**Consultation Response from KC,
Trees**

**2023/93419 Lawrence Batley Recreational Complex, New Hey Road, Salendine Nook,
Huddersfield, HD3 3XF**

**Discharge conditions 5 (cycle storage), 10 (noise assessment), 11 (hours of use), 14 (lighting),
15 (timber post), 16 (electric vehicle charging), 18 (AMS) on previous permission 2021/93645 for
installation of a new 3G synthetic turf pitch, upgraded and extended grass pitches, car-parking
and additional landscape works**

Date Responded: 11/12/2023

Tree Protection Plan

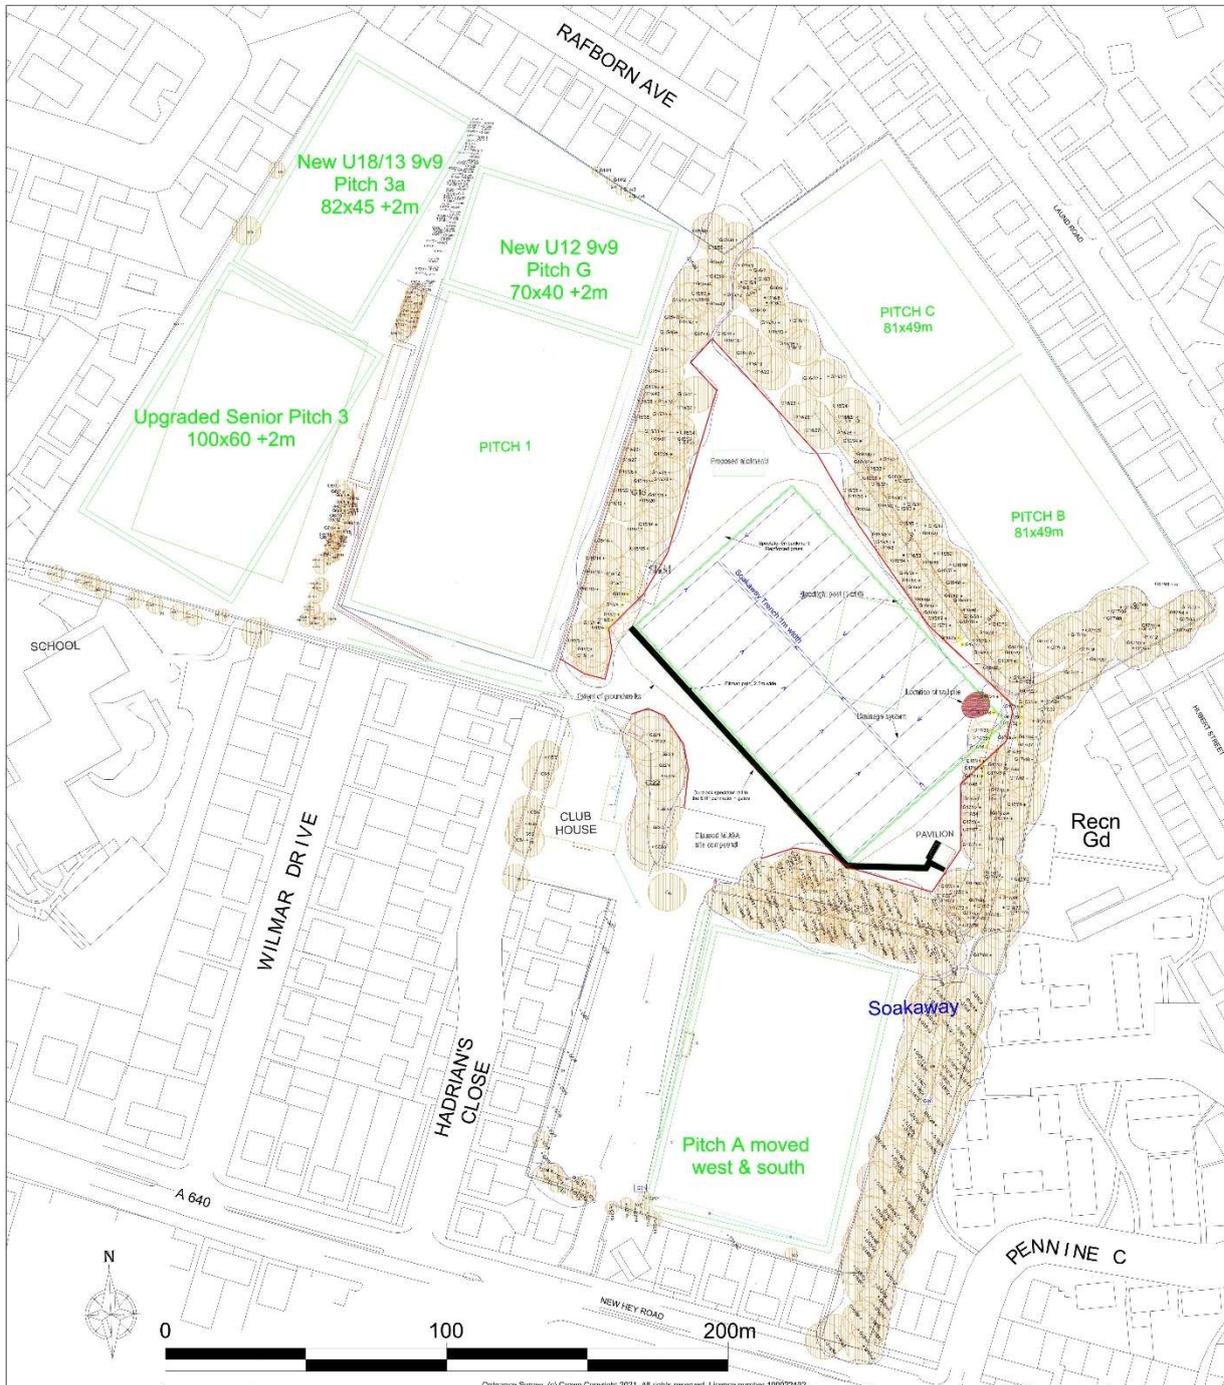
However, during the initial planning application there was pruning and tree removal proposed to facilitate the development and that is clear from reading the comments and exchanges between KC trees and the project arboriculturist at the time.

As the Client should appoint a Site Arboriculturalist whose role it will be to supervise where necessary and provide guidance on those aspects of the development which have the potential to cause damage to retained trees, either directly or indirectly. It would be helpful to have a schedule for auditable/audited system of arboricultural site monitoring, including a schedule of specific site events requiring input or supervision. For example to help ensure things like Stage 3 - Pre-construction tree works, Stage 4 - Identification and marking out of Root Protection Areas and position of temporary tree protection fencing and Stage 8 – Temporary tree protection fencing removal are carried out in accordance with the eventual approved detail and at the appropriate time.

Overall, now condition 18 can't be discharged as the information provide hasn't provided a pruning/removal specification for the facilitation tree works in relation this development and needs to provide auditable system of arboricultural site monitoring.
